Road Safety Audit Stage 1 Response Report

Report title:	Road Safety Audit – A29 Shripney Road
Date:	3 rd February 2020
Document reference and revision:	200108
Prepared by:	Nick Jeans
On behalf of:	Avon Traffic & Safety Services

Project:	Land at Shripney Road, Shripney
Report title:	Road Safety Audit Stage 1 Response Report
Prepared by:	
Name:	Dave Tighe
Position:	Director
Signed:	
Organisation:	Highgate Transportation Ltd
Date:	5 th February 2020
Approved by:	
Name:	
Position:	
Signed:	
Organisation:	
Date:

This site is currently a field with existing residential development to all sides except the east which are fields. The development is for 46 residential units and will be served by a new ghost island right turn junction broadly at the location of the existing field access gate.

TITLE: PROPOSED SITE ACCESS ARRANGEMENTS		
DATE: 05/06/19	DRAWN BY: BL	CHECKED: DT

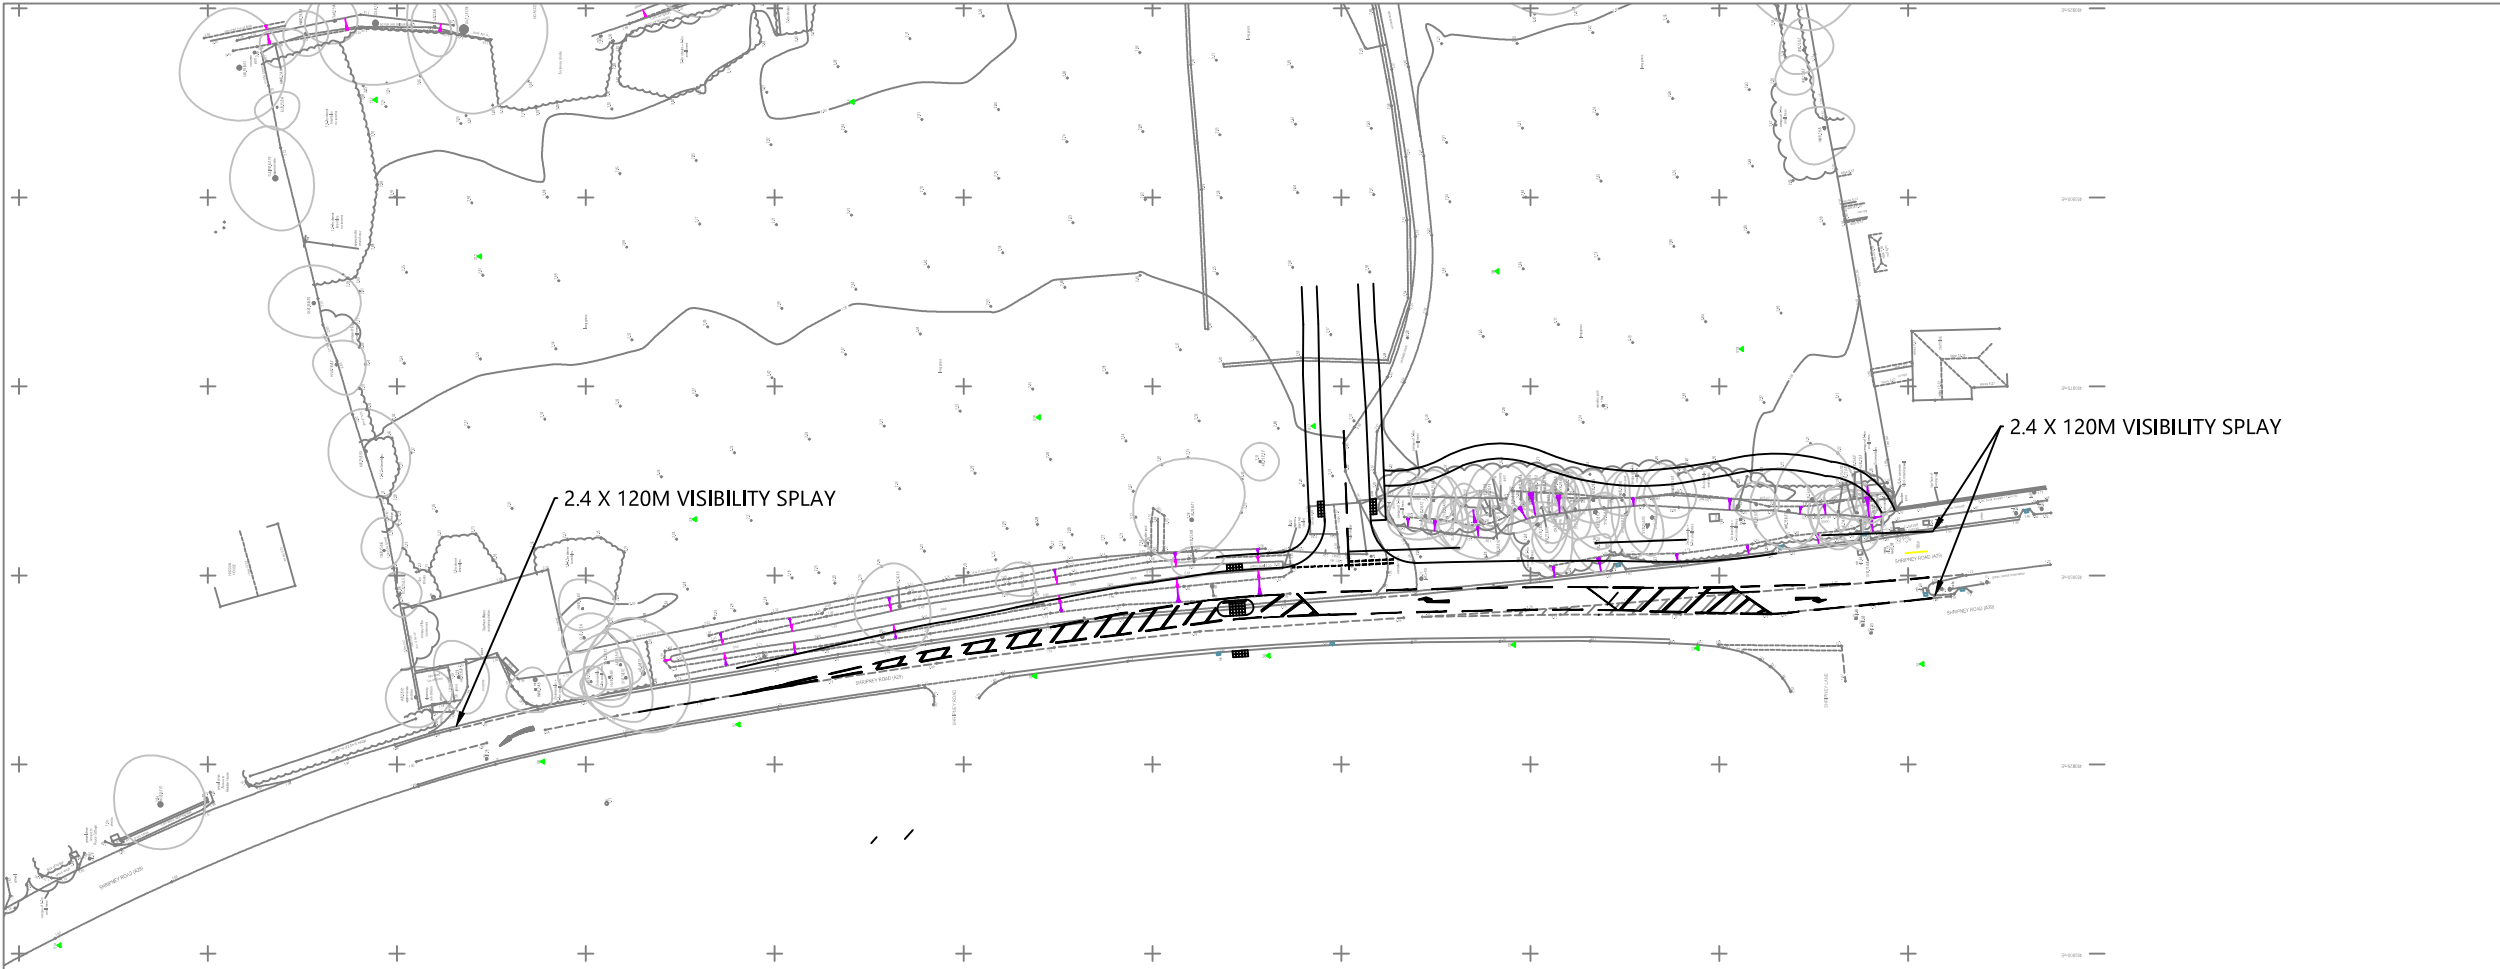
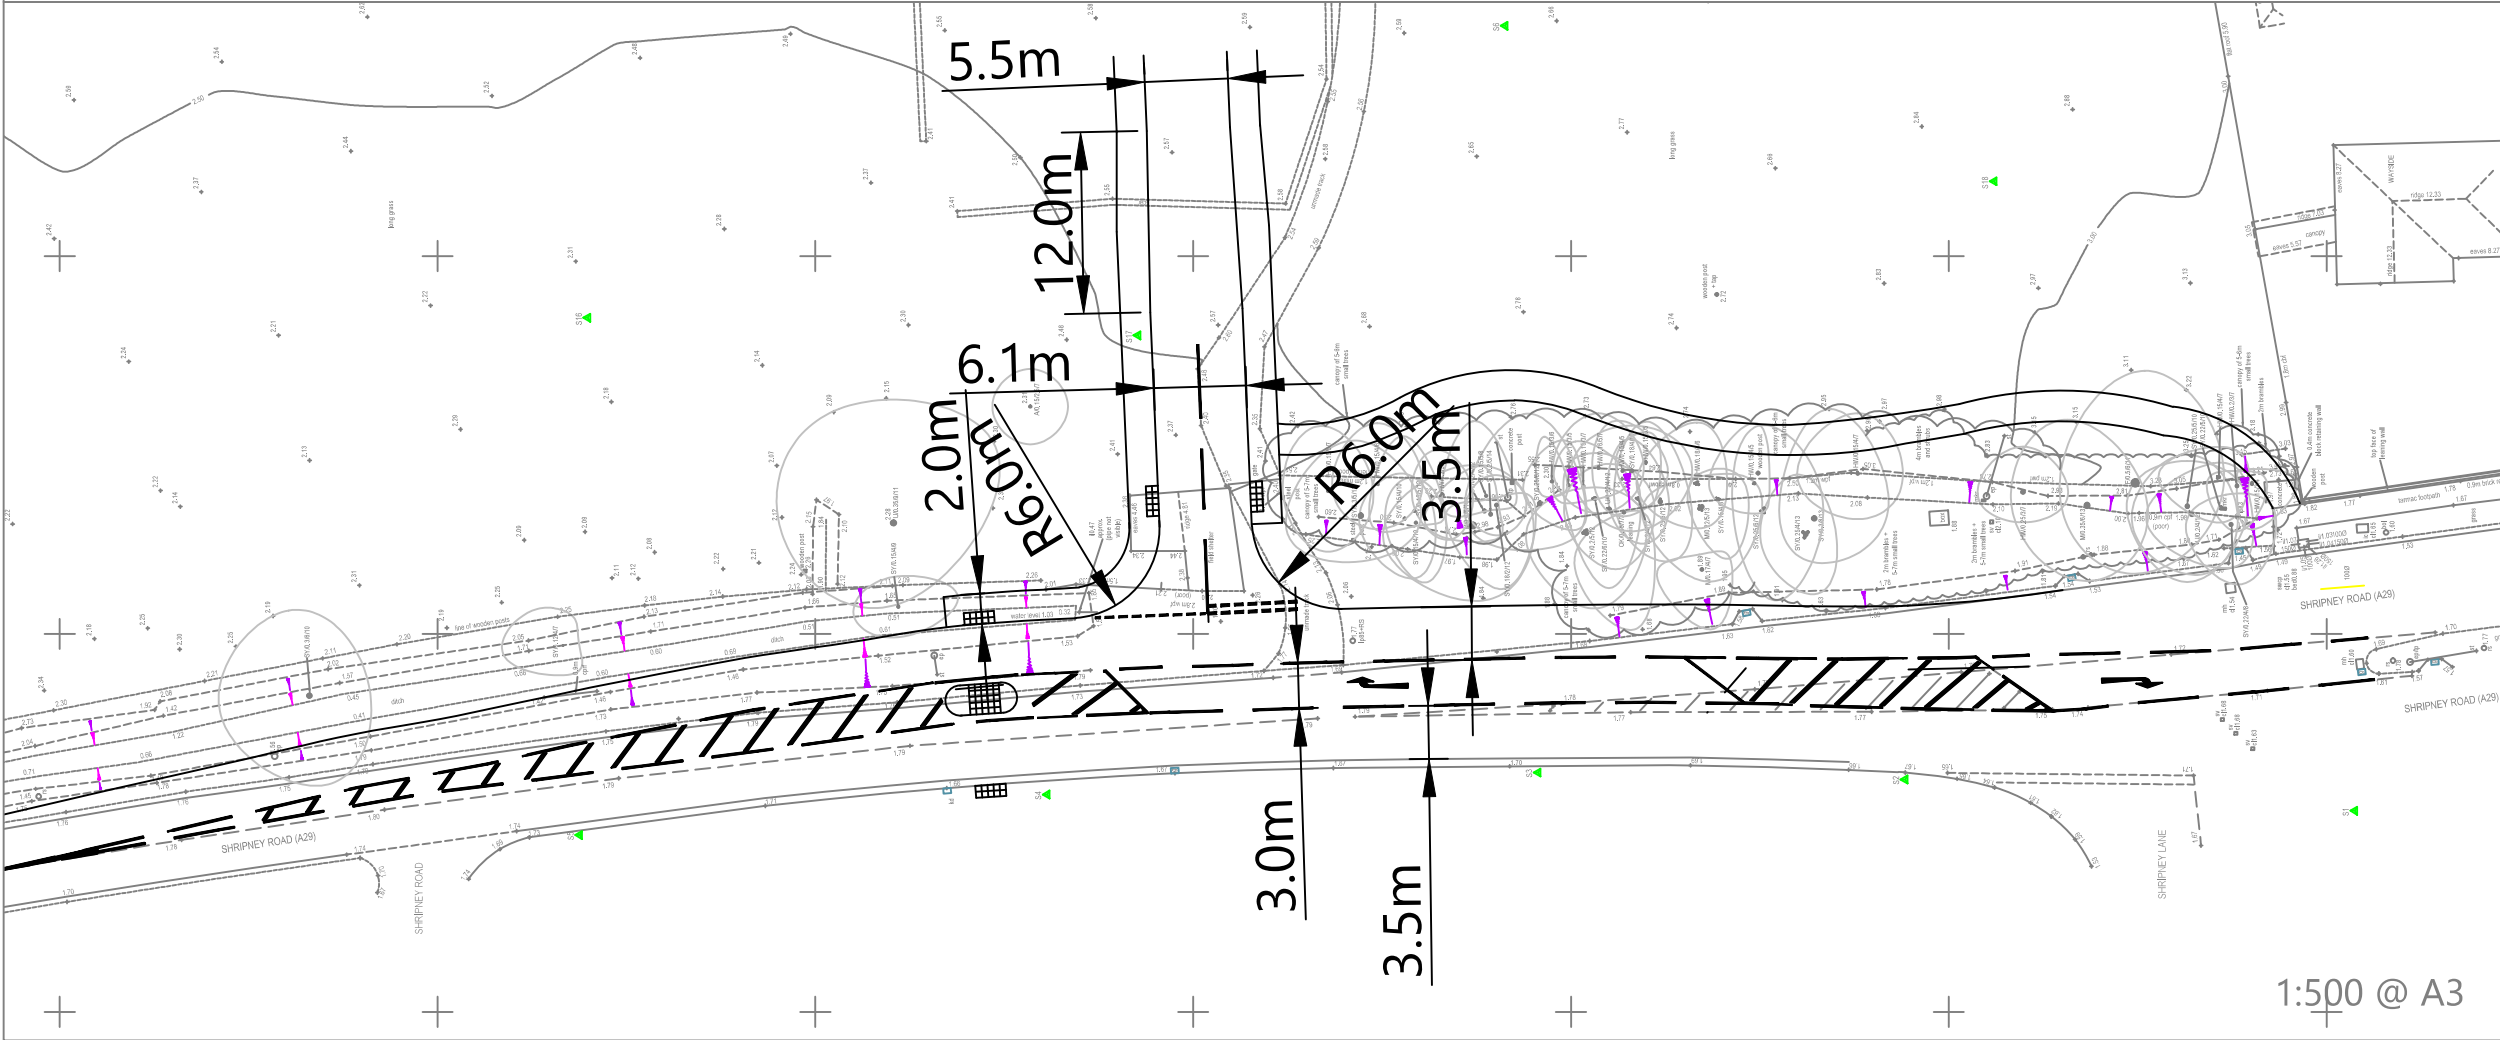
RSA Problem	RSA Recommendation	Design Organisation Responsible	Overseeing Organisation responsible	Agreed RSA Action
2.1 The existing informal pedestrian crossing at this location is proposed to be upgraded so that it is realigned and incorporates an area of tactile paving. The boundary wall and fence of an adjacent residential property inhibits visibility to the proposed crossing of those approaching from the south along the dual carriageway. This increases the likelihood of pedestrian/vehicle conflict particularly for vulnerable groups such as older users and those with mobility and visual impairment. The high approaching speeds observed on site together with the lack of any deflection for vehicles turning in to Shripney Lane will increase the risk of such collisions.	Realign and build out the existing kerbline at this corner to increase visibility to and from the crossing. The resulting increased deflection together with the reduced entry radius at this corner will influence entry vehicle speeds and minimise the risk of conflict with those crossing.	WSCC requested this proposed crossing arrangement instead of a proposed build-out. We consider that a build-out to both sides can be provided but that this current arrangement is an improvement on the current situation.

2.2 The existing boundary fence and wall inhibits visibility to the proposed pedestrian crossing point and increases the risk of vehicle/pedestrian conflict. Evidence on site also indicates that drivers turning left out of Shripney Lane mount the kerb as their attention is drawn to vehicles approaching from the south (often at speed),	Increase visibility at this point by building the kerb further out into the carriageway. If the existing kerbline was realigned on both sides of the junction and the refuge island was omitted visibility would be improved on both sides of this junction (see problem 2.1).	As above

along the dual carriageway.				
2.3 The existing road layout at the A29/Shripney Lane junction and the provision of the new central refuge island means that those approaching from the south (often at speed and overtaking) will be squeezing past this point while pedestrians are waiting to cross increasing the likelihood of vehicle/pedestrian conflicts. Site observations also indicate vehicle wheel tracking very close to the existing kerblines.	Install measures along the northbound approach of the dual carriageway in advance of the Shripney Lane junction to alter driver behaviour at this point. This may include reducing the northbound carriageway to a single lane of traffic (which will also improve visibility which has been raised as a problem in section 2.1), by the use of extra hatching on the approach, and possibly a local build out of the central reservation, appropriately signed; enhancing the existing signage; and reducing the existing speed limit. Also reinstate the existing edge of carriageway markings to guide vehicles away from the edge of the carriageway.	See 2.4 below. The running lane is proposed to be slightly widened in this location past the proposed western pedestrian dropped kerb and tactile paving, therefore it is considered that this point should be monitored and considered further at RSA Stage 2 and 3

2.4 Northbound vehicles approach the site at speed, with some using the offside lane to overtake. A lack of judgement by an overtaking driver, who leaves it too late to pull to the left, is at risk of colliding with the proposed island.	Install measures along the northbound approach of the dual carriageway in advance of the Shripney Lane junction to alter driver behaviour at this point. This may include reducing the northbound carriageway to a single lane of traffic by the use of extra hatching on the approach, and possibly a local build out of the central reservation, appropriately signed; enhancing the existing signage; and reducing the existing speed limit.	It is considered that given the existing alignment of the ghost right turn lane for Shripney Lane, an approaching northbound vehicle should be contained to the running lane in this location. If this is observed to be an issue following RSA Stage 3 then the developer will fund the installation of white line hatching in the offside northbound lane of the dual carriageway to guide drivers to merge into the nearside lane sooner

driver behaviour at this point. This may include reducing the northbound carriageway to a single lane of traffic by the use of extra hatching on the approach, and possibly a local build out of the central reservation, appropriately signed; enhancing the existing signage; and reducing the existing speed limit.				
--	--	--	--	--

2.5 Install measures along the northbound approach of the dual carriageway in advance of the Shripney Lane junction to alter	Remove the existing vegetation and establish methods to permanently maintain required sightlines.	Agreed
